ENG-CDR21010-R3-CDs-Barbarick-Interim.pdf Markup Summary

VOLLMER ROAD (NORTH)
ROADWAY PLAN & PROFILE

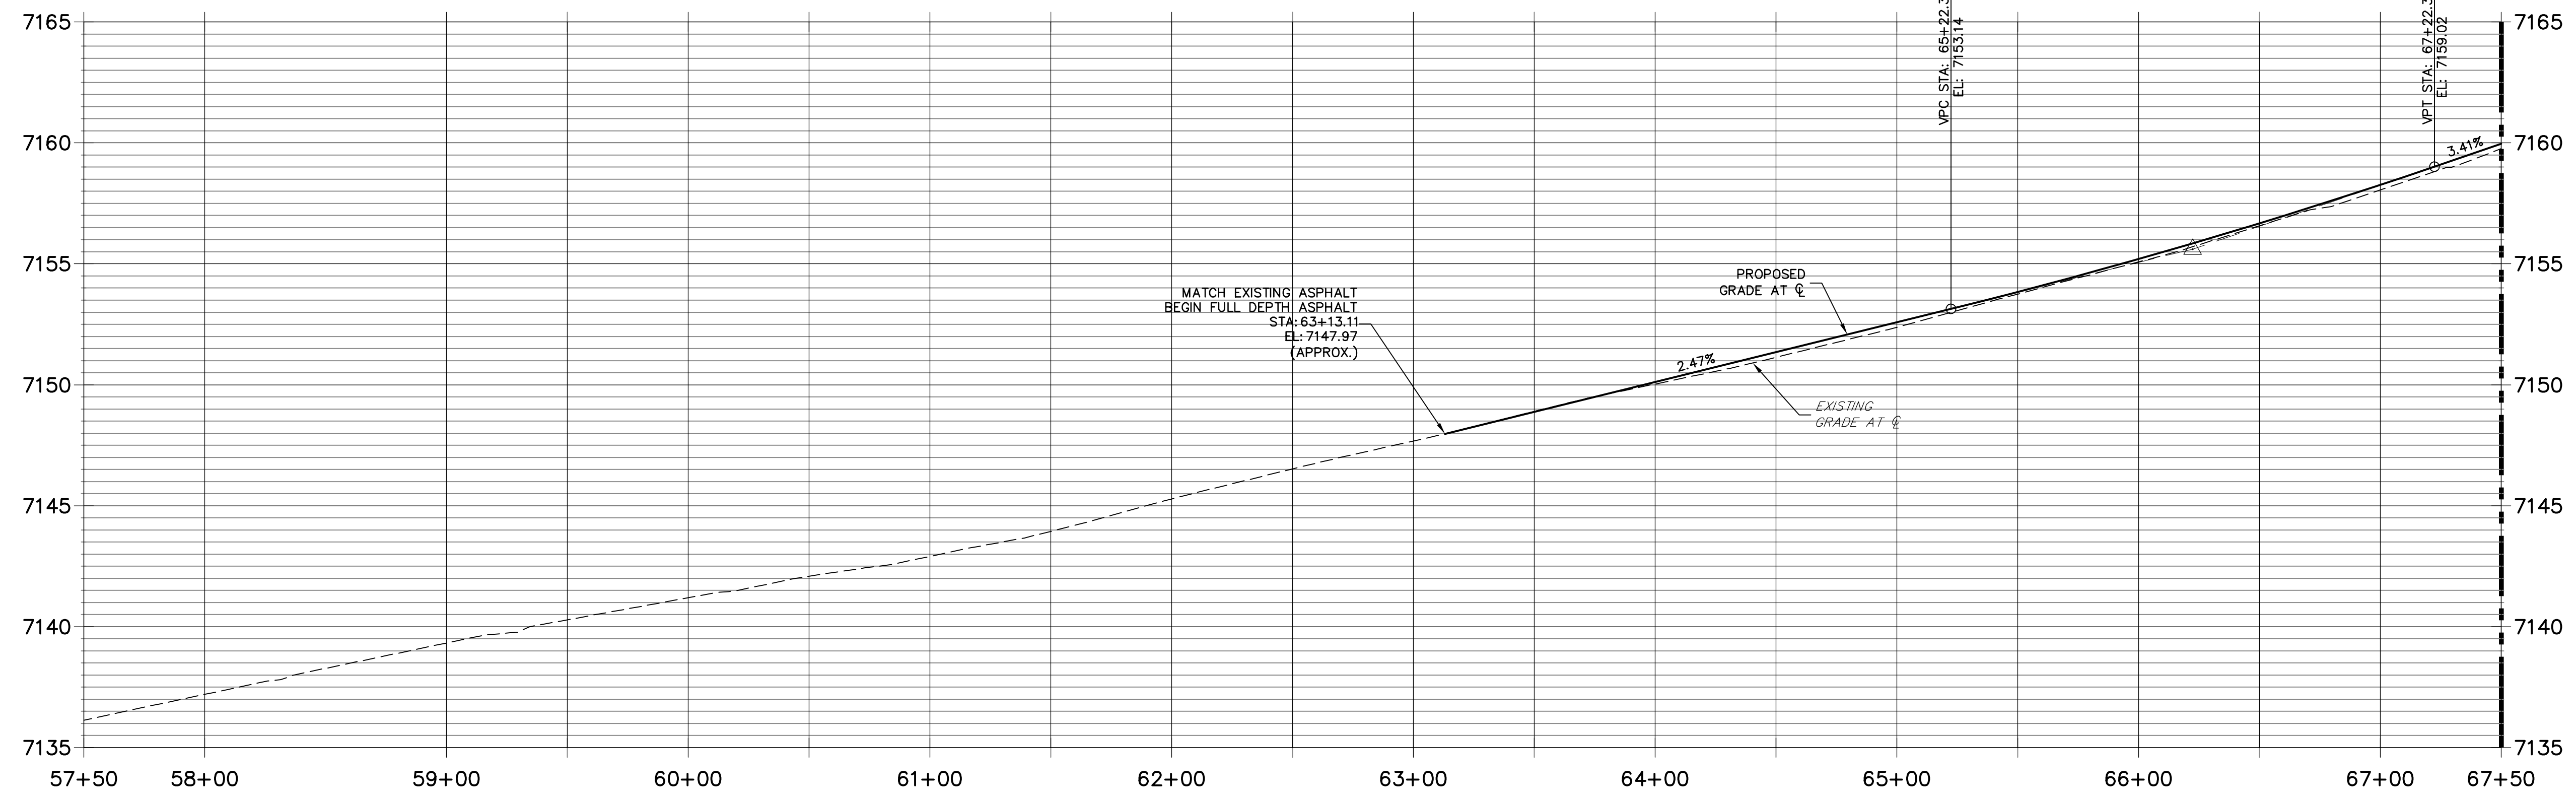
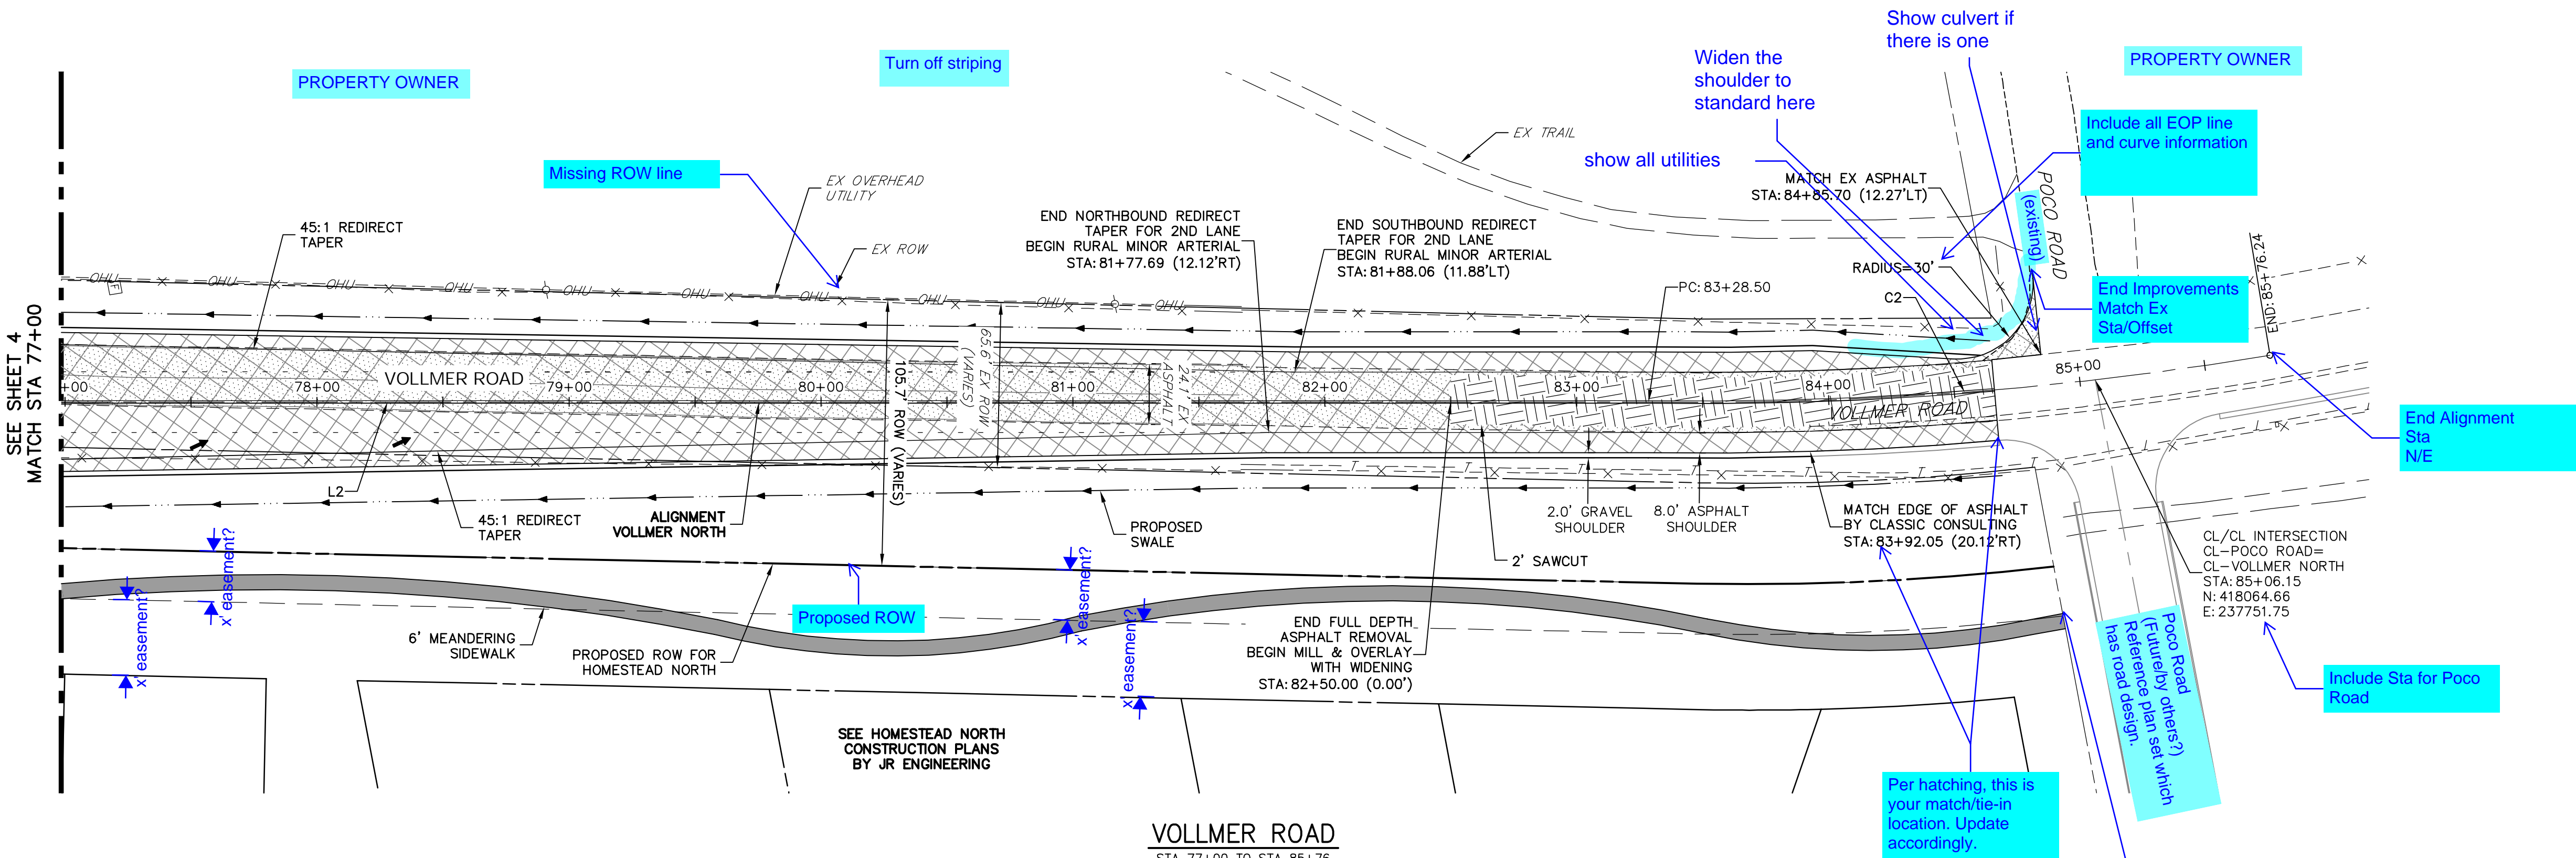
Relocate/Remove culvert?

Remove/relocate existing sign?

Update label, Sta should be between 18+00 & 19+00

Fix overlapping text

Fix overlapping text

Provide Sta for where improvements end

Show edge of pavement

Label ROW

Label easement/Tract

2 row lines?

Label ROW
